Town & Country Planning Act 1990 (as amended)
Town and Country Planning (Development Management Procedure) (England) Order 2015
Approval of details reserved by condition imposed under ref APP/C3810/W/18/3213581
(AL/129/17/PL) relating to Condition No 4 - materials & finishes.
Forge House Nyton Road Westergate PO20 3UP

Condition Number 4

Arun District Council have decided to **APPROVE details reserved by this condition**

**External Walls:** Flint Blocks.

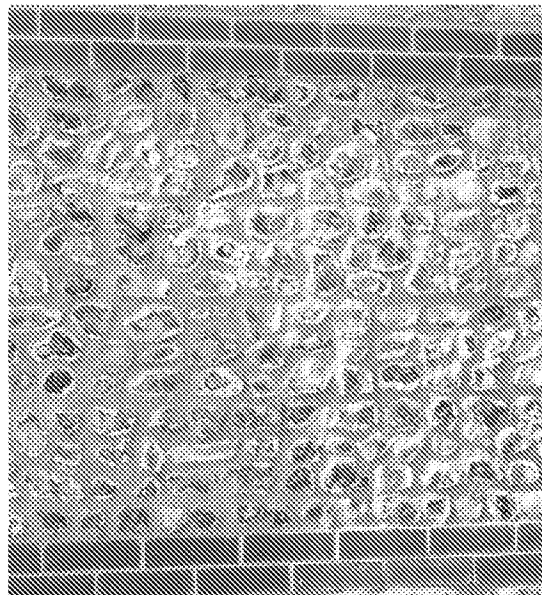
The materials would appear to reflect those in the local area. I note that the intention is to use Dorset Flint and Stone Blocks Ltd: Knapped field flint for the flint sections of elevations. This is unfortunate, as it is normally possible to view the coursing of the larger cementous blocks that are used to construct this type of walling. This would detract from the other walling on the site.

However, the Conservation Officer has confirmed that, whilst a more traditional method of construction for the flint walling to the new buildings would be their preference, this is not sufficient reason to refuse, they raise no objection to the proposal on heritage grounds and would be content with an approval of
